From: Amanda Scholes **On Behalf Of** Planning.Responses
Sent: 28 September 2018 12:49
To: Amber Willard
Subject: FW: AL/82/18/LDO

From: Mark Warwick
Sent: 28 September 2018 12:03
To: Amber Willard
Cc: Planning.Responses
Subject: RE: AL/82/18/LDO

I have an application AL/82/18/LDO at Aldingbourne Nurseries . It's a new type of application whereby it extends PD rights to people within agricultural businesses.

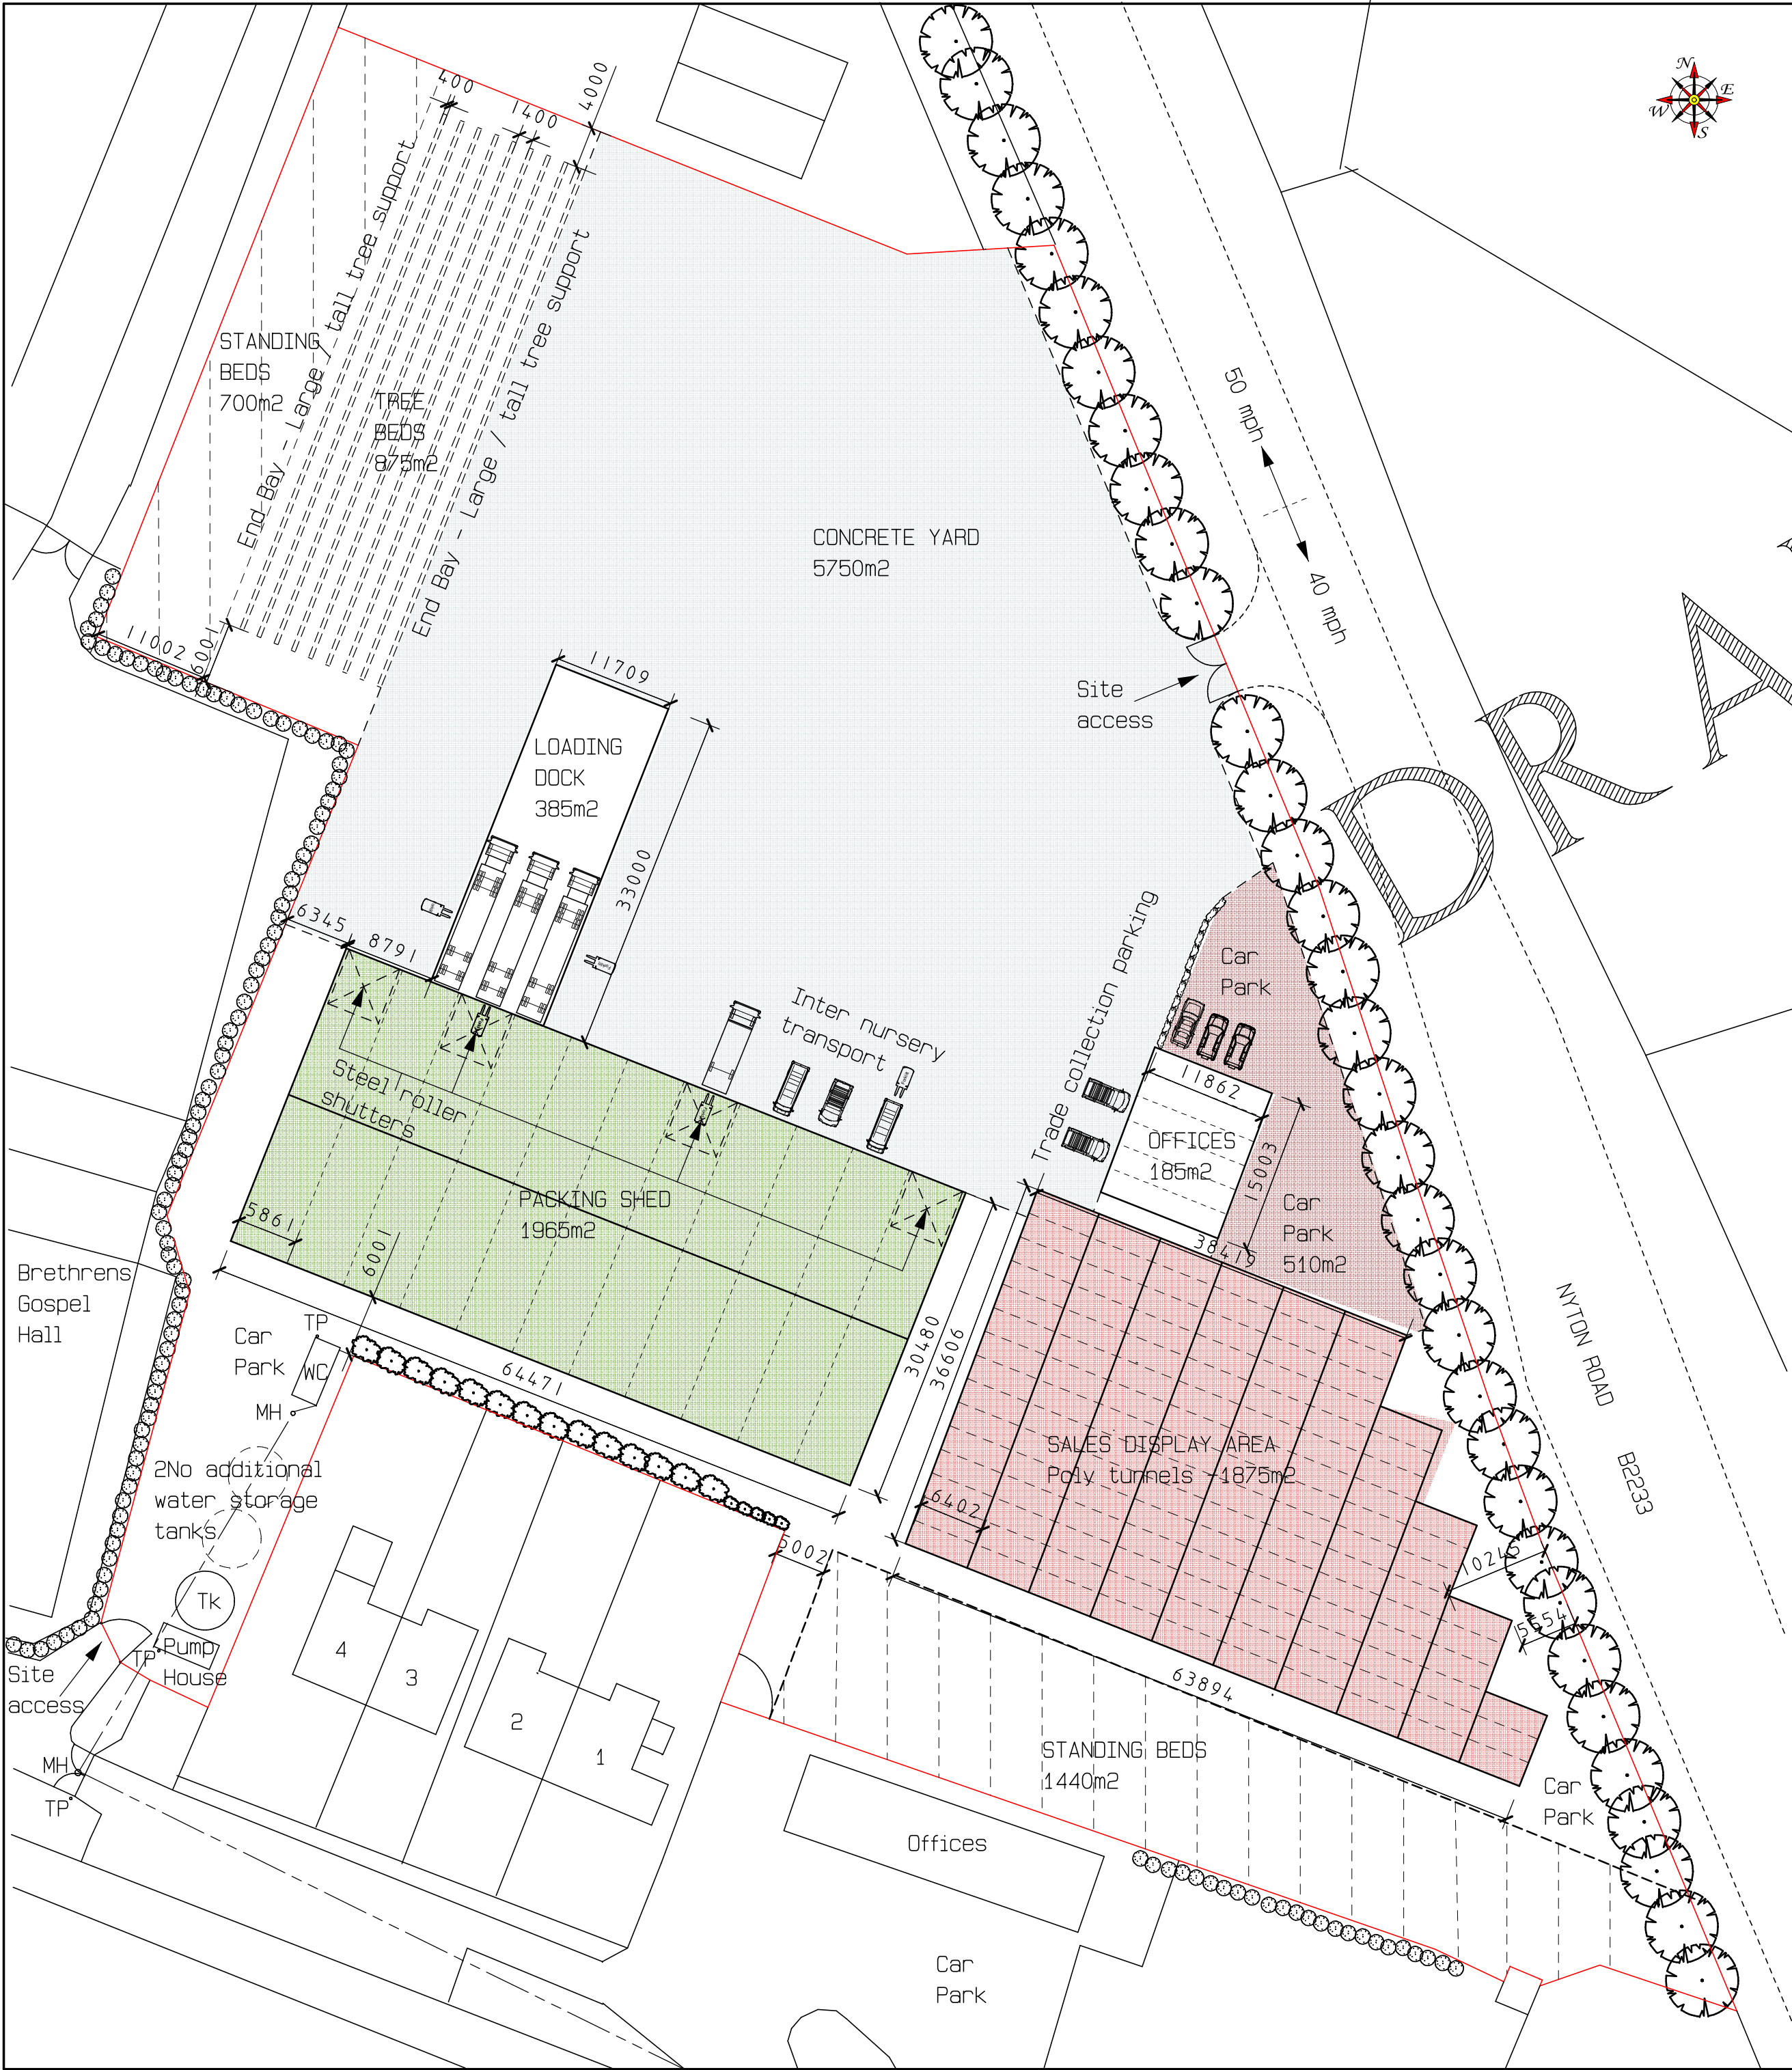
- The dominant tree line along the site's boundary with Nyton Road consists predominantly of Leyland cypress of varying form and quality, notable more for its group value in screening and sheltering the site. Within the tree line are a number of Italian alder which need not be subject to the same extent of height reduction (as proposed) and would have some visual amenity.

- There is a group of silver birch at the south-east corner of the site which may be under 3rd party ownership. One of these (stem diameter est.550mm) is mature and in good condition with fine form. They have not been identified within this proposal and so no clear plan to protect these trees exist. The larger specimen is an outlier of the impressive birch tree linear group which grows alongside the driveway leading up to Limmer Pond House.

- No obvious RPA incursion (ground excavation) has been proposed, although I cannot be sure of this in the absence of a detailed tree survey schedule and Tree Constraints Plan which overlays the site proposal.

- The applicant will need to submit a Tree Protection Plan (TPP), which describes measures that will be 'fit for purpose' and meet the requirements of British Standard 5837:2012, to respect and protect trees that may be adversely affected during site re-development. This refers predominantly to the dominant tree group along the Nyton Road boundary and the group of birch trees at the south-east corner.

- Development including enhancement/alteration to existing hard surfaces/compacted ground is proposed, including the provision of car parking areas - but yet to be specified in detail. The development as proposed is achievable without causing significant harm to valuable trees, although it has not yet been satisfactorily demonstrated that this will be achieved and therefore the application in its current form does not meet the criteria for an exception.

- As it stands, I would have to lodge an **Objection** to this scheme. On receipt of a satisfactory TPP and written confirmation that RPA incursion will not occur; I ought then to be in a position to recommend approval.

PROPOSED WATER STORAGE TANKS - PLANS AND ELEVATIONS

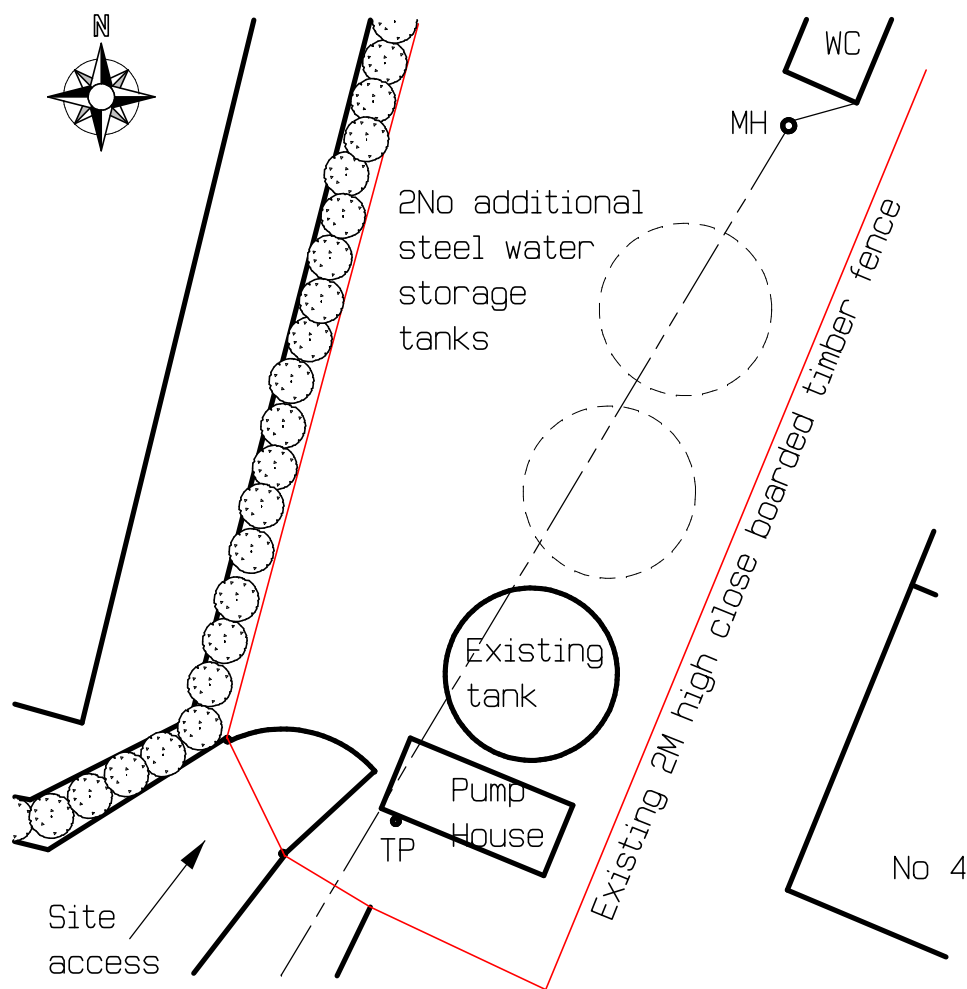
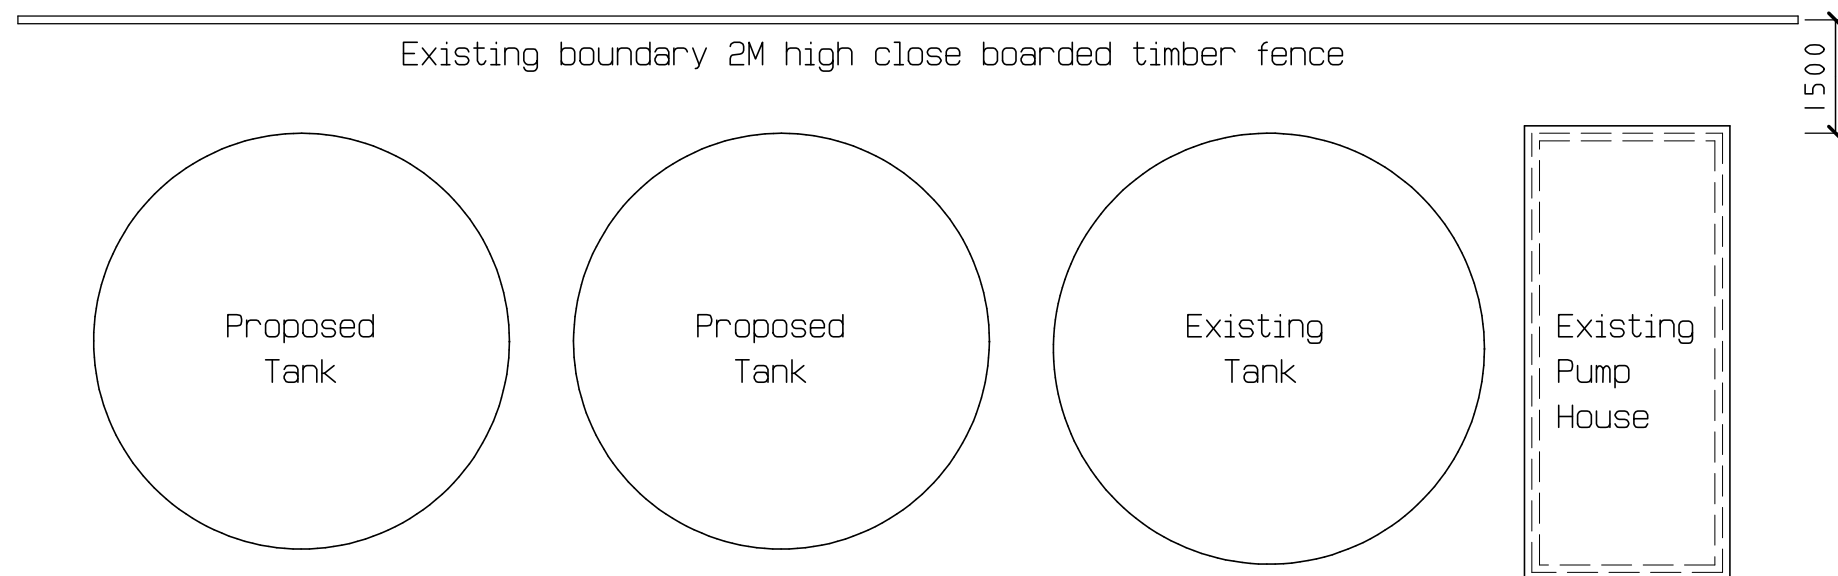
1. Design and Method Statement, Grove Design UK, 26th July 2018
2. Tree Report, Round Top Trees Ltd
3. Existing Site Layout, Grove Design UK, Dwg.no. 18-07-GD-217-01A-DA, July 2018
4. Proposed Site Layout, Grove Design UK, Dwg.no. 18-07-GD-217-02A-DA, July 2018
5. Proposed Water Storage Tanks, Grove Design UK, Dwg.no. 18-08-GD-217-09, August 2018
